TR010064: Application by National Highways for the M60/M62/M66 Simister Island Interchange Project

The Examining Authority's Written Questions and requests for further information

Issued on 22 October 2024

Reproduced by permission of Ordnance Survey on behalf of HMSO. © Crown copyright and database right 2024. All rights reserved. Ordnance Survey Licence number 100030649.

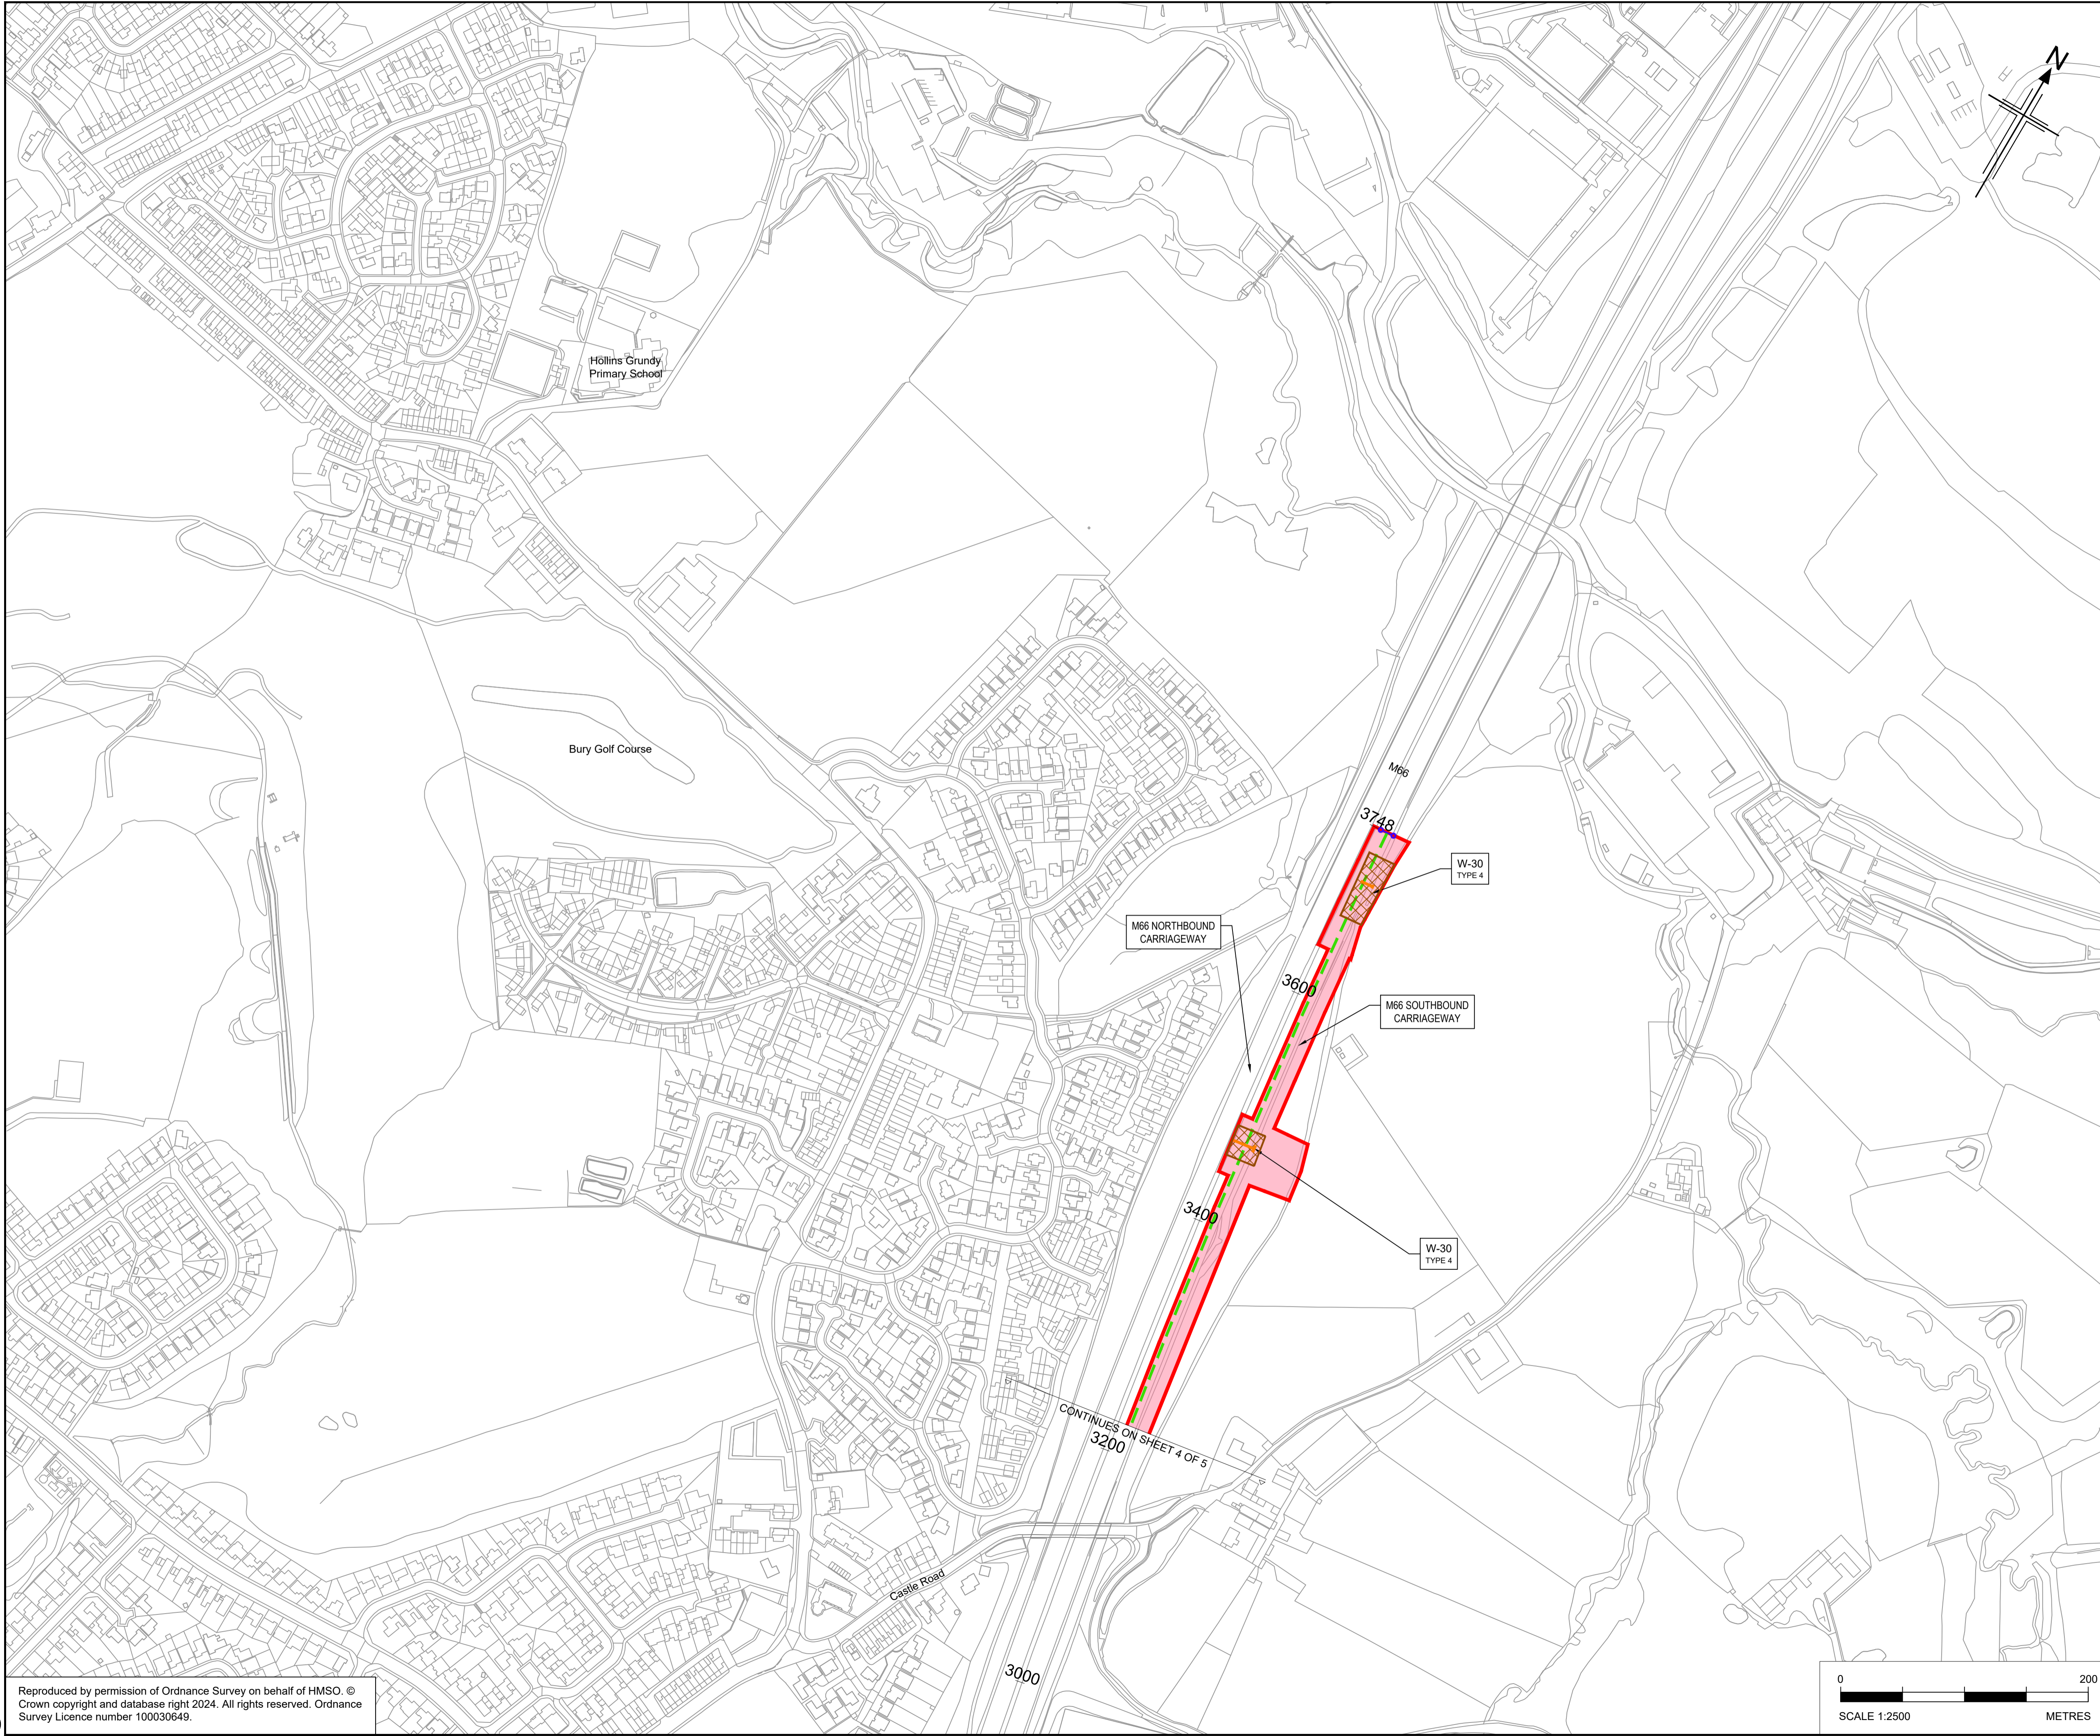
ExQ1	Question to:	Question
CA.1.9	Applicant	<p>Works Plans</p> <p>The Works Plans [AS-006] contain areas of white land, which are unexplained in the legend. The ExA consider Works Plans should be fully explanatory and indicate all land and its intended works. Amend the Works Plans, and fully annotate each area of land with a Work No.</p>
CA.1.10	Applicant	<p>Land Plans</p> <p>The Applicant's response in [REP2-007] to D1 submission [REP1-033] states "<i>The Applicant confirms that, in respect of plot 1/33b, no temporary land take is required, and the Applicant is seeking permanent Rights for access in connection with future maintenance of the Scheme only</i>". The Land Plans [AS-005] shows plot 1/33b as blue which is described as "<i>Land to be used temporarily and Rights to be acquired permanently</i>". Are there any other plots, which are shown as blue, where it is not intended that they will be used temporarily and only Rights are sought to be acquired? Consider how the plots could be coloured on the Land Plans to clarify where only Rights over land are being sought and provide revised Land Plans accordingly.</p>
